From: Amanda Scholes on behalf of Planning.Responses
Sent: 14 March 2019 08:48
To: Planning Scanning
Subject: FW: Saltbox- Drainage - BE/2/19/DOC

Please upload the ADC Drainage Engineer's consultation response onto Ocella for BE/2/19/DOC

From: Laura Gibbons
Sent: 13 March 2019 16:08
To: 'David Omonitan'; Arfon Hughes
Cc: Mr Will Marsh; Keith Sarchett; Chris Thrippleton; Nia Russell; Michael Eastham; Steve hawkins
Subject: RE: Saltbox- Drainage

Given the number of points outstanding and the level of work required to rectify these I am going to be recommending that the DOC application for condition 9 (BE/2/19/DOC) is refused at this stage. I am keen to work with you to ensure that when a revised DOC is submitted it meets our requirements.

Drawing Title: PHASE 1 DRAINAGE STRATEGY PLANNING SHET 2 OF 3

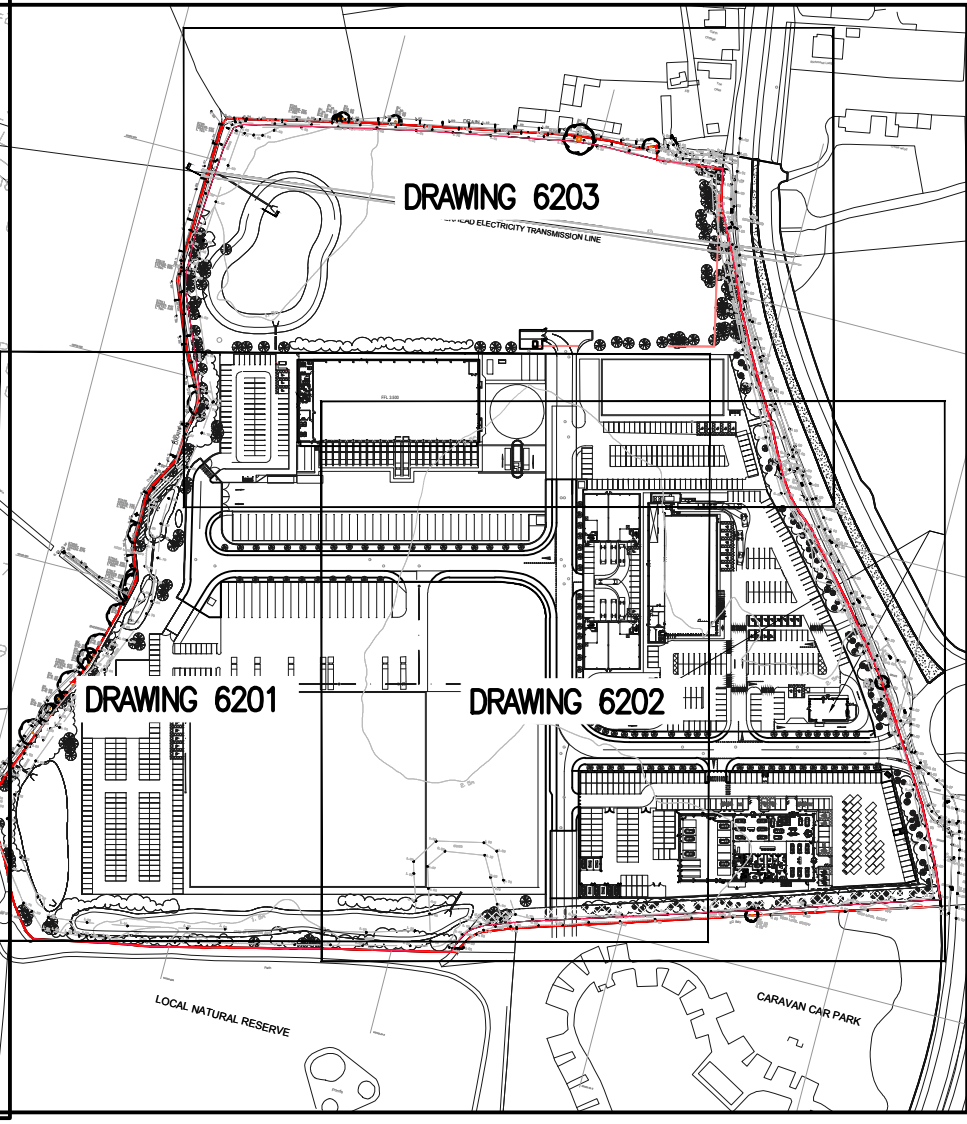
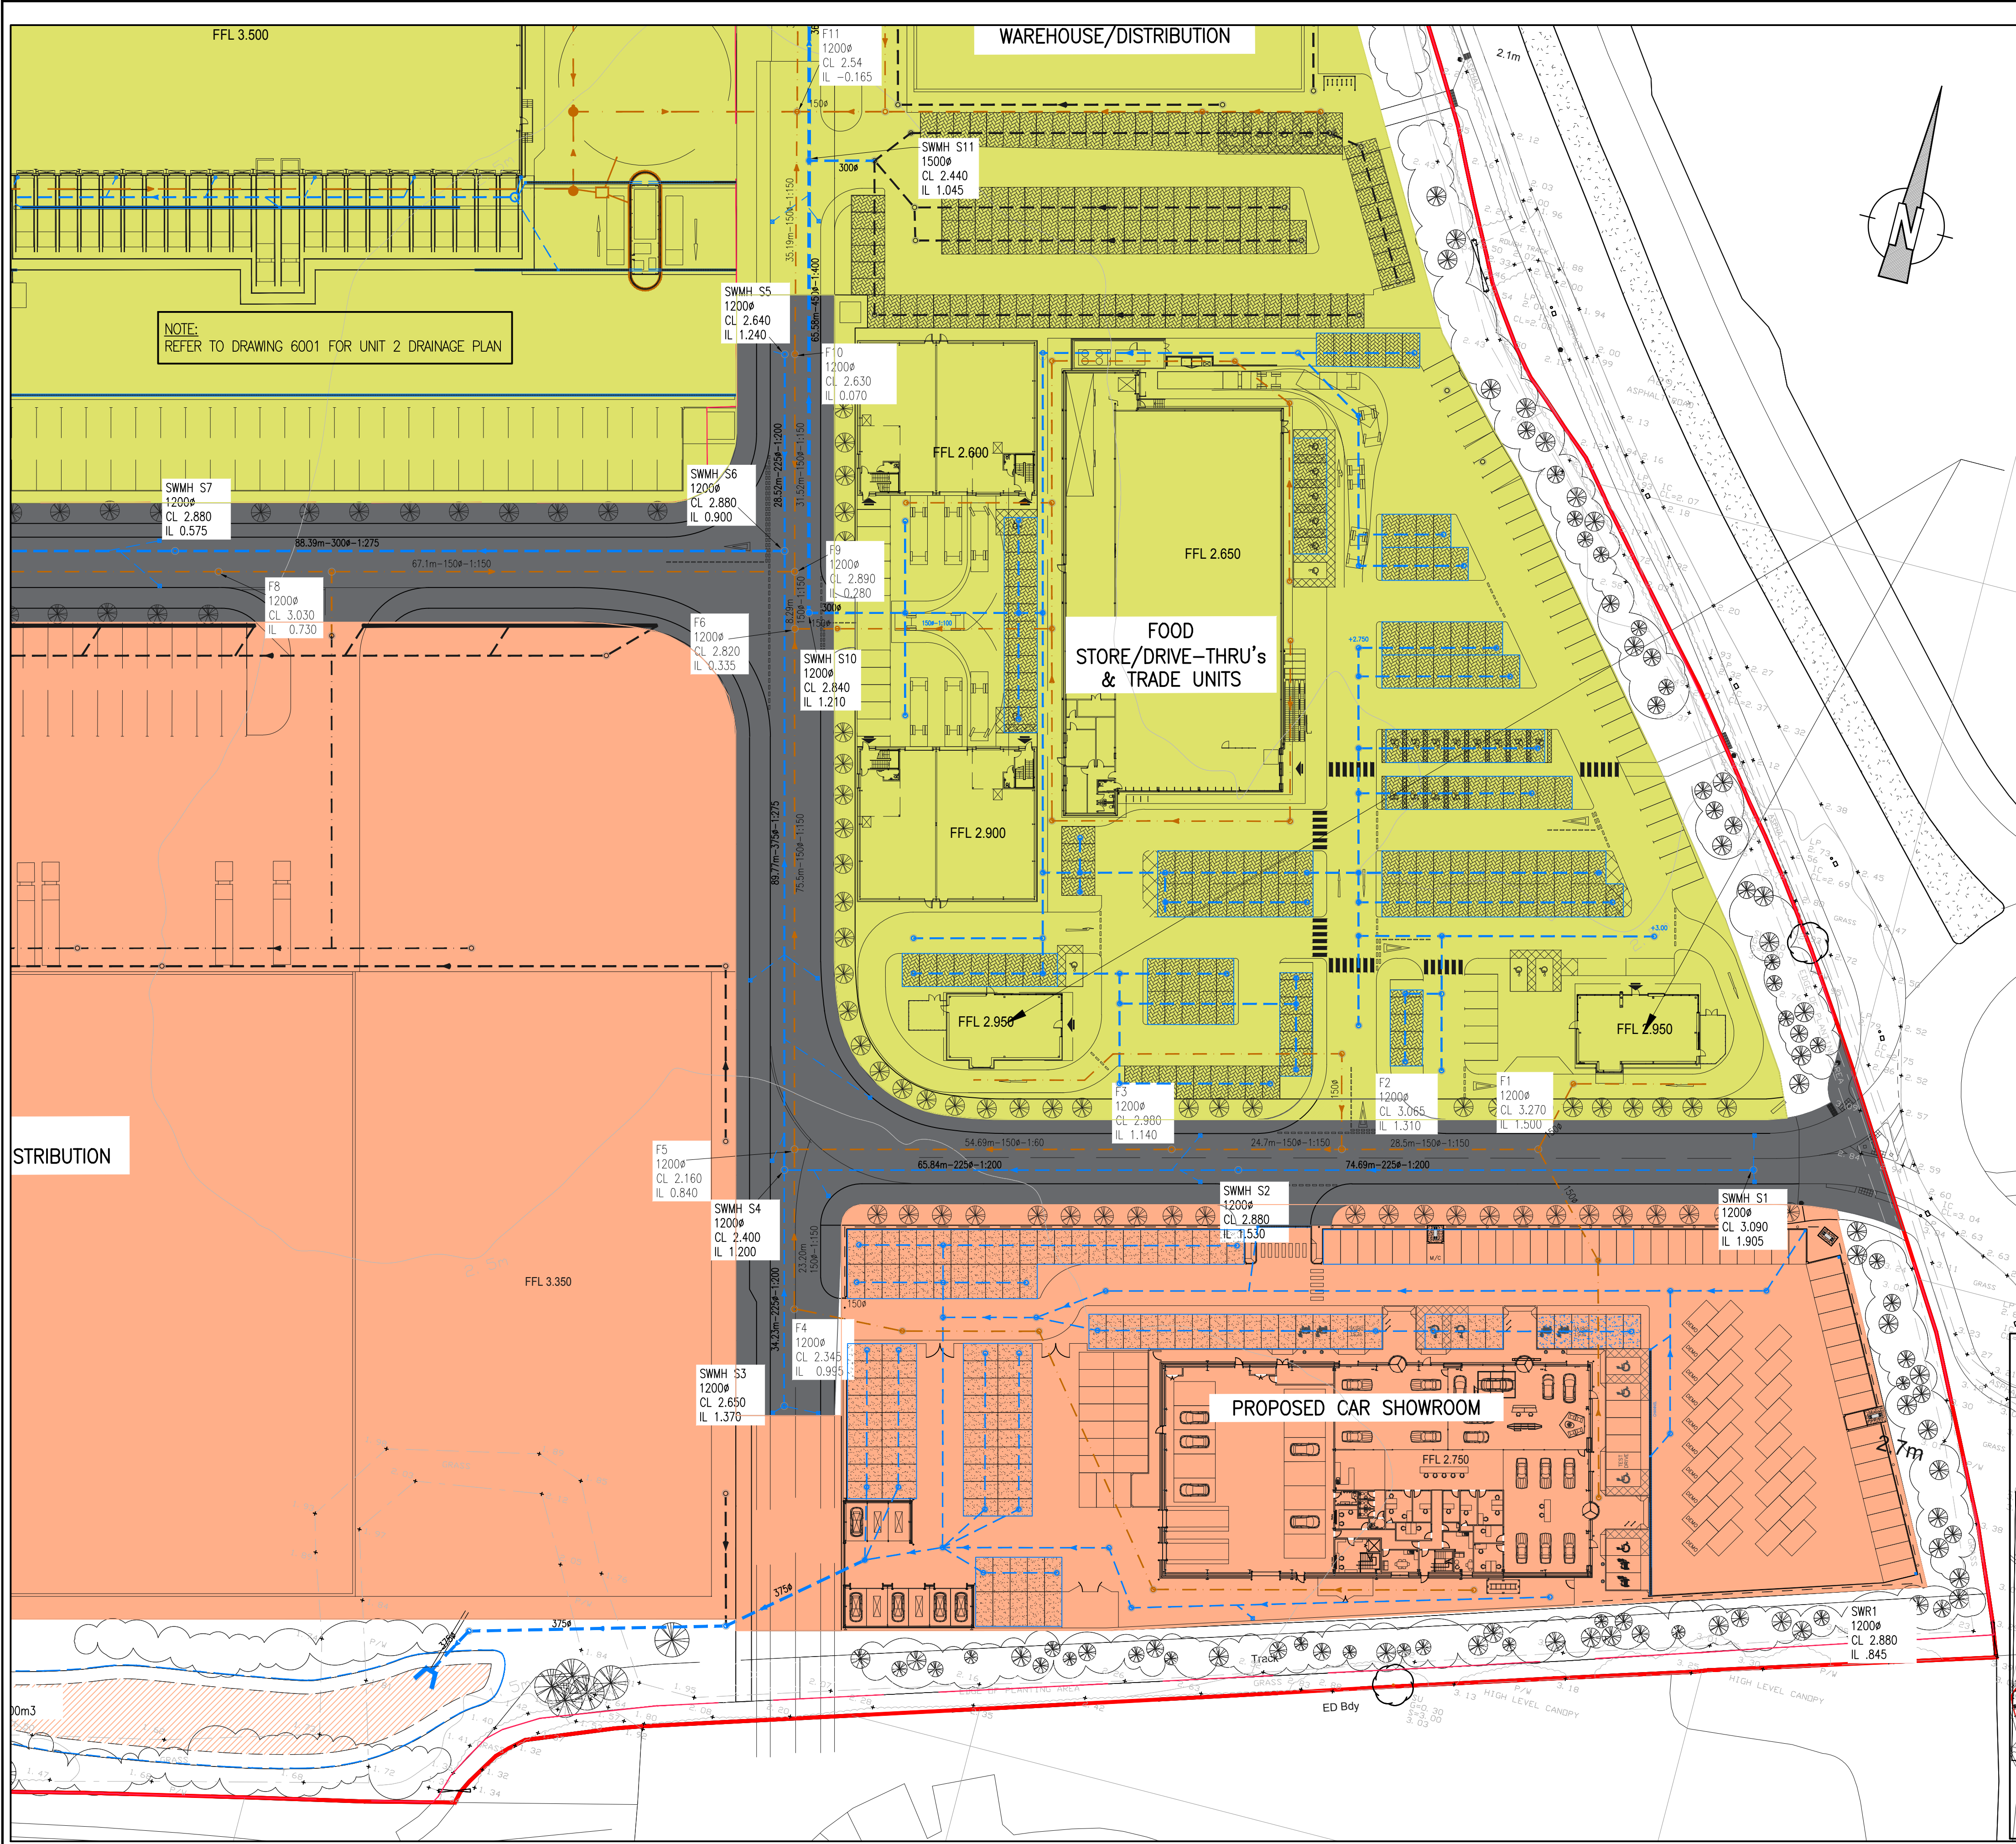
1. I am disappointed by the limited extents of permeable paving you are proposing given that infiltration rates are good. Please utilise permeable paving more throughout the site.

3. You are proposing on using permeable paving in the car park area for unit 2, which is the area where poorest infiltration test results were seen. The infiltration rate in this area is not suitable to rely on infiltration and therefore in this location I agree that a connection to the attenuation areas is required, however insufficient detail has been provided regarding the level at which the connection is to be provided and for which storm events these connections will come on line for. Please provide this detail

Number: 6103

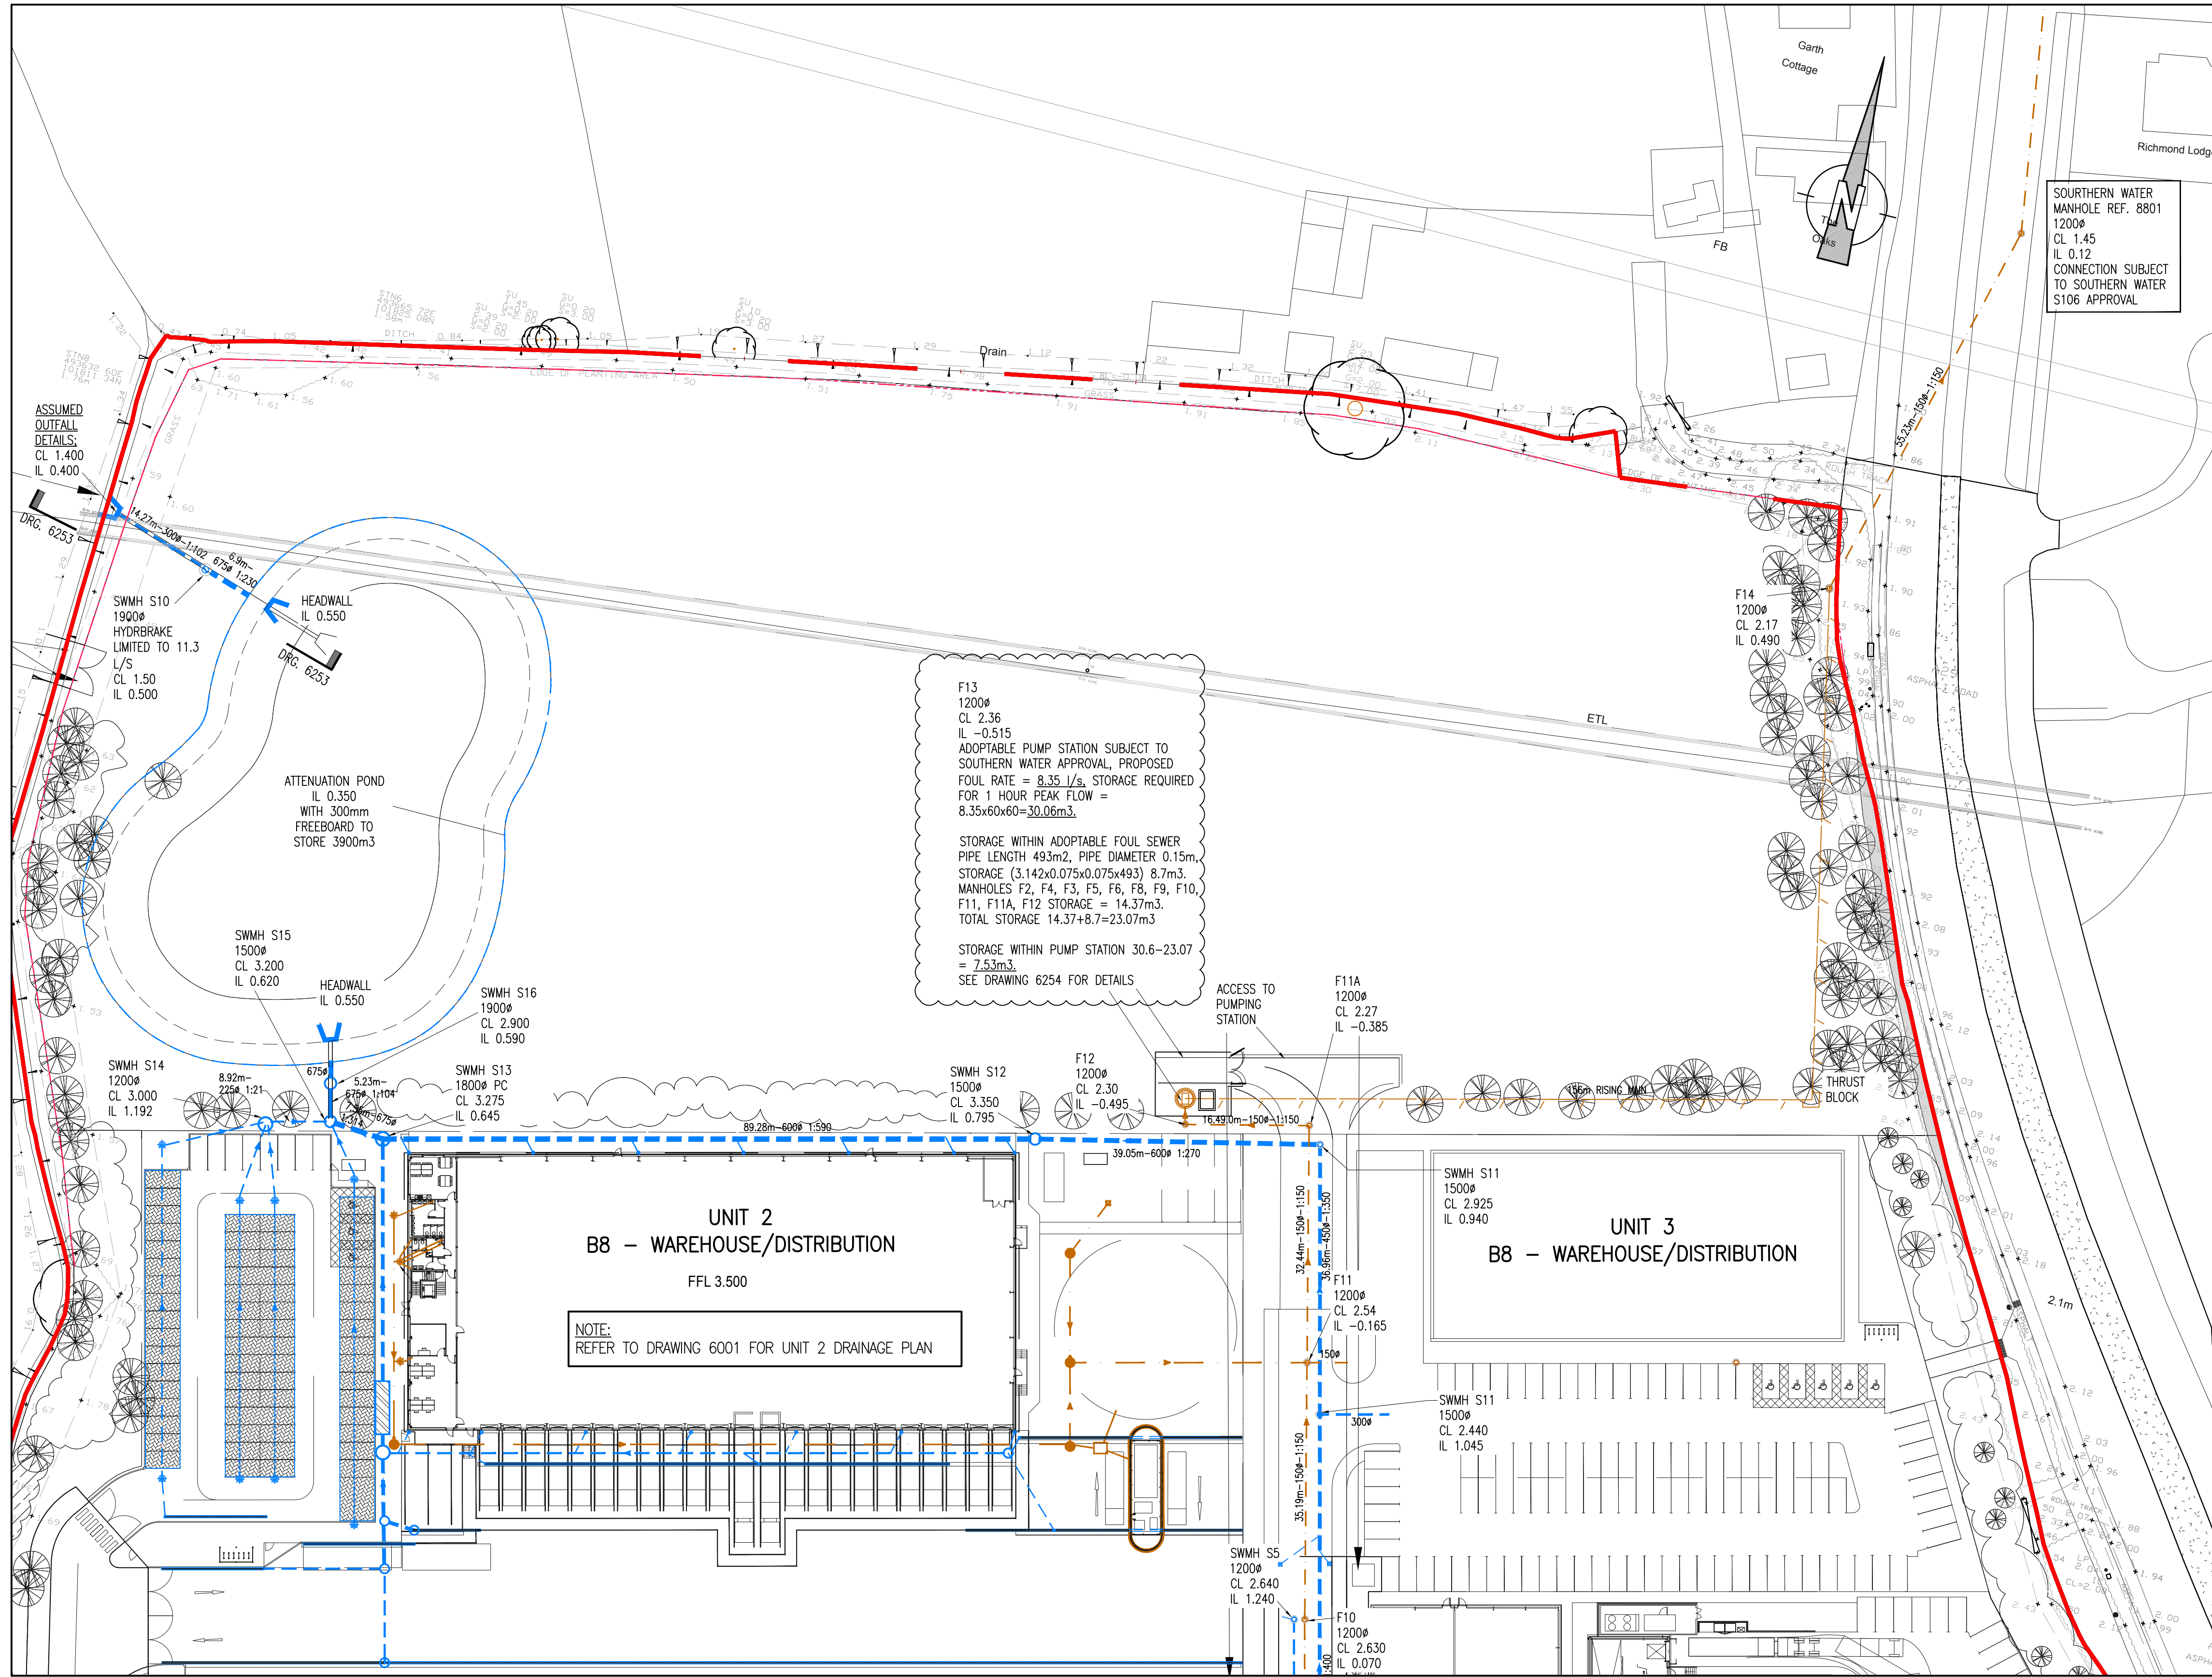
2. Infiltration rates found at TP101-TP104 and TP106 are good and I would request you use permeable paving throughout the site. Where half drain times meet our requirements, and adequate capacity is available I would not accept a connection to still be provided to the wider network.

10. I do not like that maximum modelled water levels in the pond cross section you have provided are getting close to existing ground levels and have therefore resulted in you specifying bunds. Please provide 300mm freeboard below surrounding ground levels.

11. I require further cross sections to be provided of the ponds which clearly show inlet and outlet arrangements. As a minimum I require two cross sections per pond.
